HINCKLEY NATIONAL RAIL FREIGHT INTERCHANGE

Project reference TR050007

Applicant's response to deadline 3 submissions [Part 8 - Parish Councils]

Document reference: 18.13

Drawing Title
**JUNCTION 17 - B581 /
HINCKLEY ROAD / NEW
ROAD
PROPOSED SIGNALS**

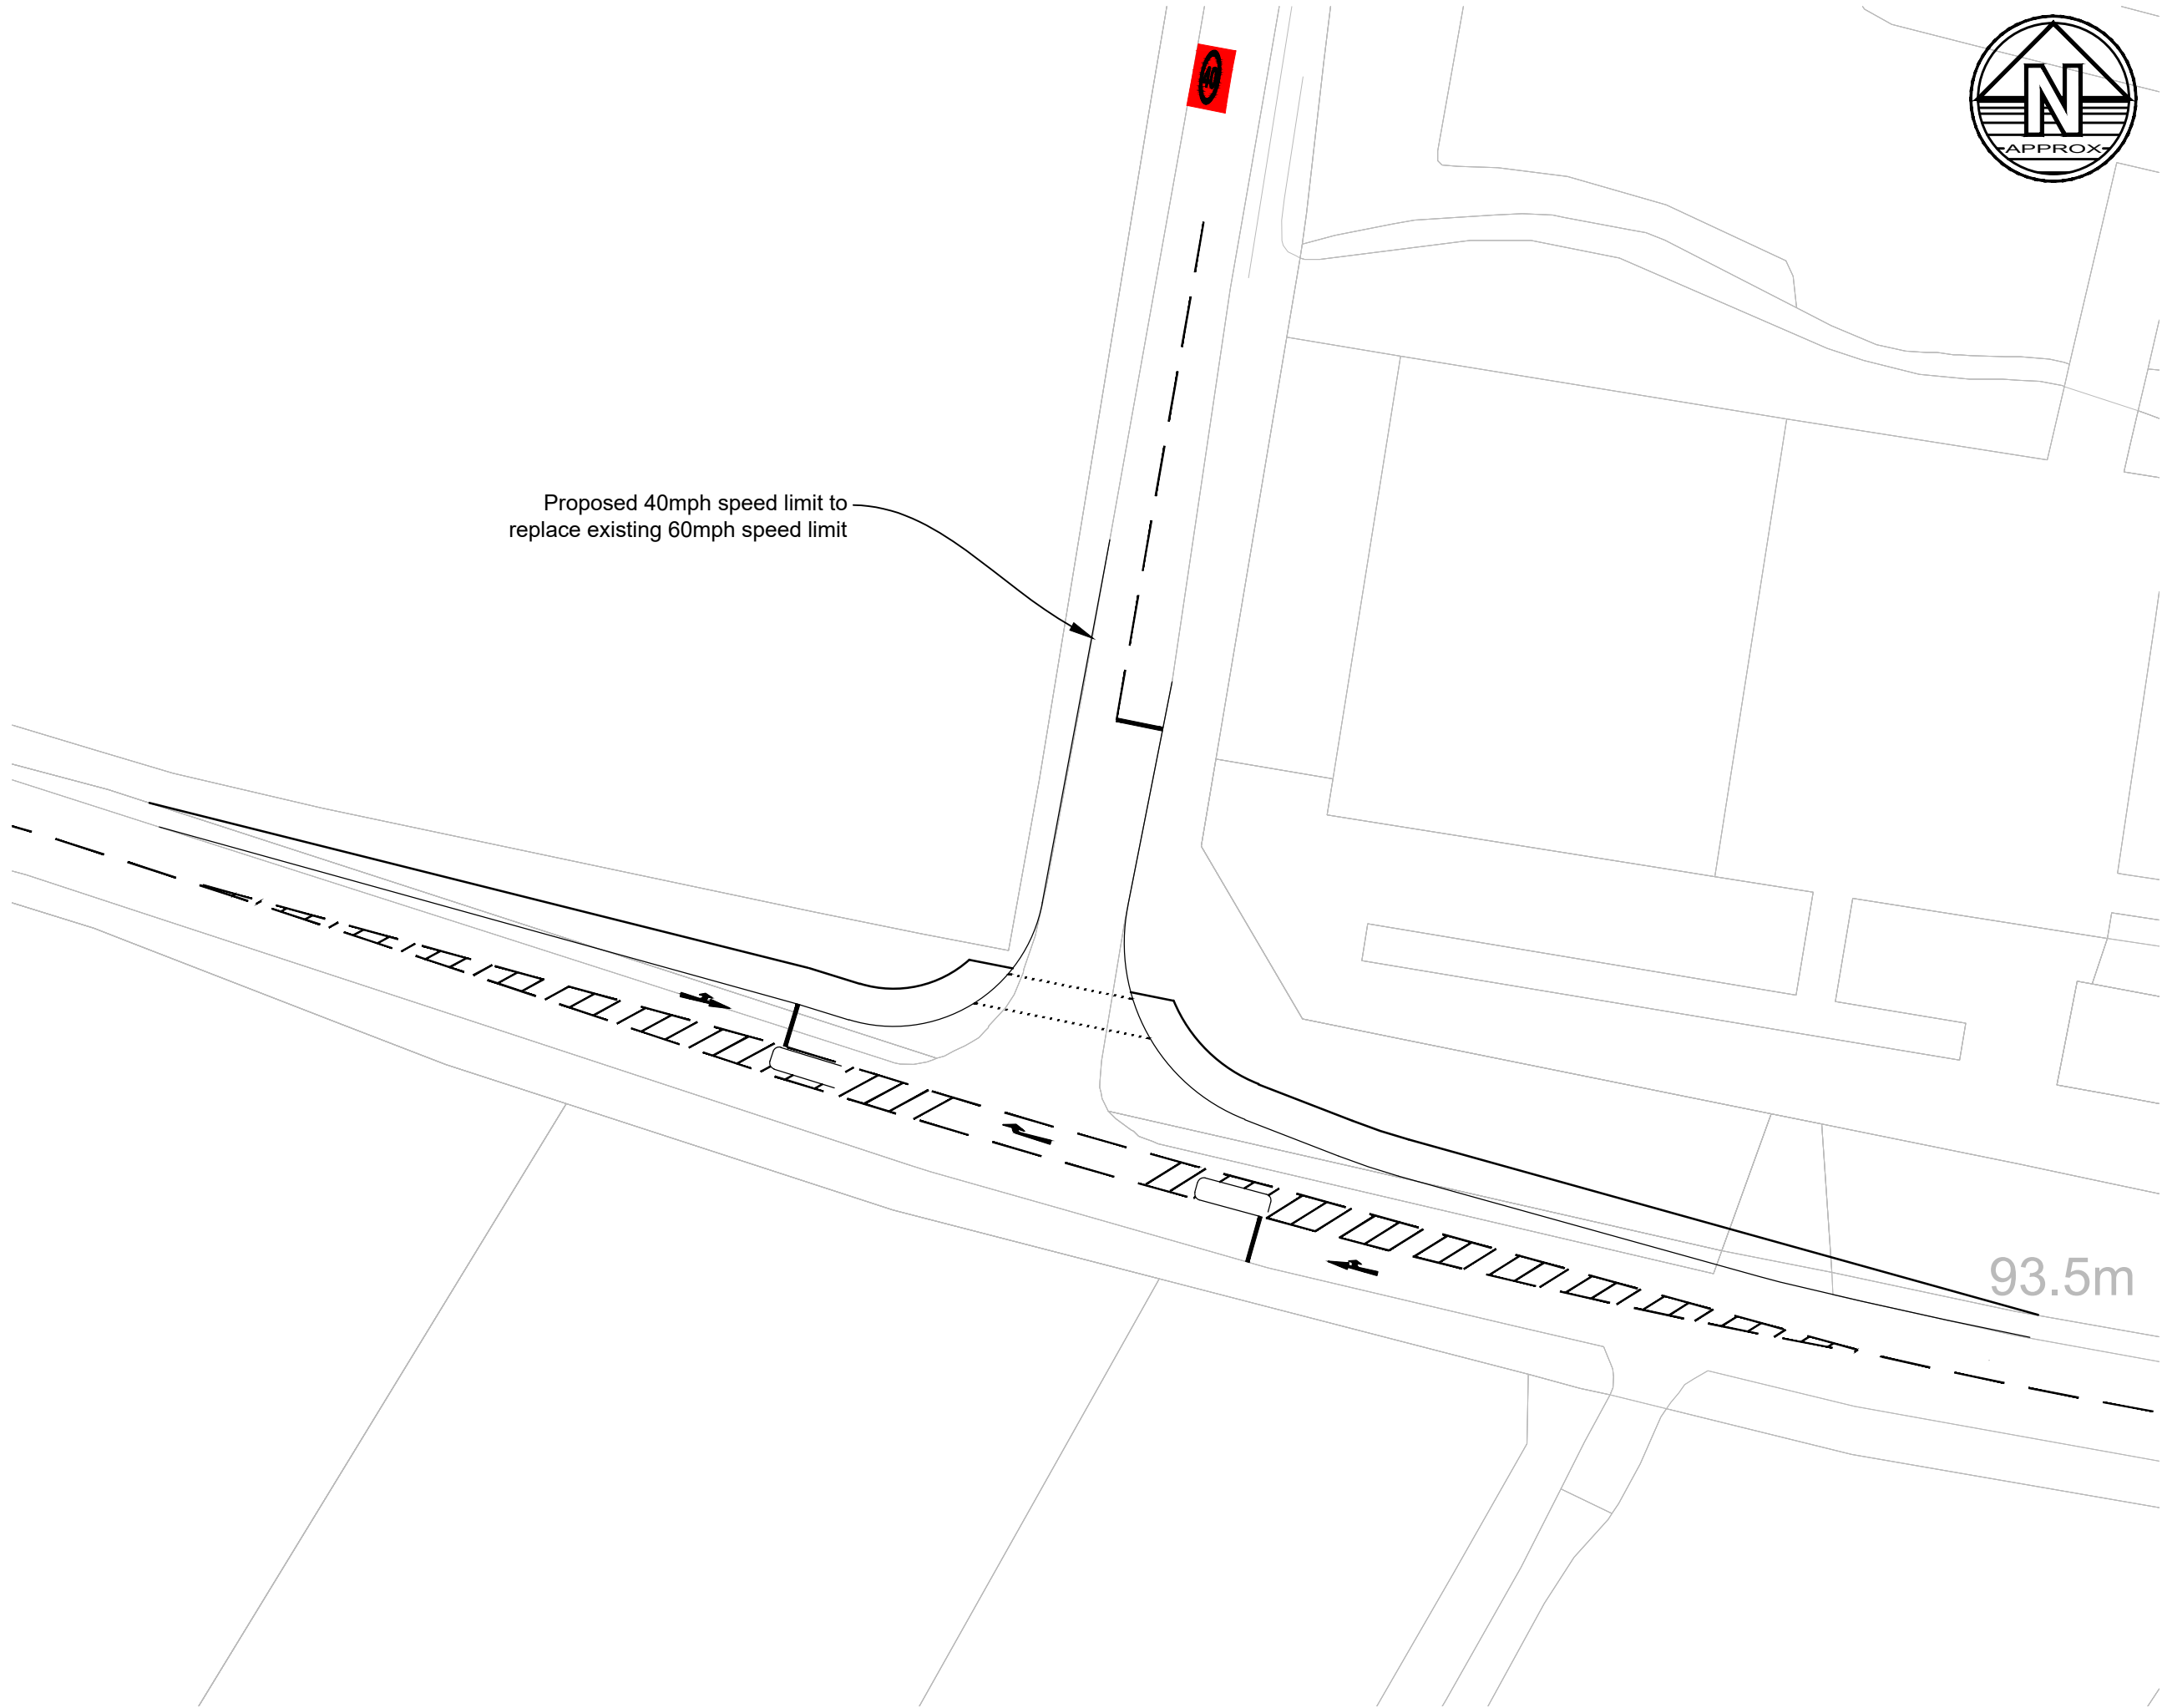
| Response Number | Matter | Applicants Response |
|-----------------|--|---|
| | <p>impacted. The quantum of highways works that will surround Elmesthorpe in every direction and at almost every connecting junction will isolate villagers and it is not considered reasonable.</p> <p>4.5. The mitigation proposed at New Road/Hinckley Road/Station Road B581 of introducing traffic lights to impose a delay in order to deter HGV traffic generated and/or reassigned as an effect of the proposed development, is deemed wholly unsatisfactory. To propose mitigation in the form of making a well performing junction into a poorly performing junction to produce delays, is an effect that will be permanently suffered by the villagers of Elmesthorpe (and Stoney Stanton) as they try to move about their daily lives.</p> | <p>Mitigation is proposed to ensure traffic moves more efficiently through the junction whilst enhancing pedestrian safety.</p> |
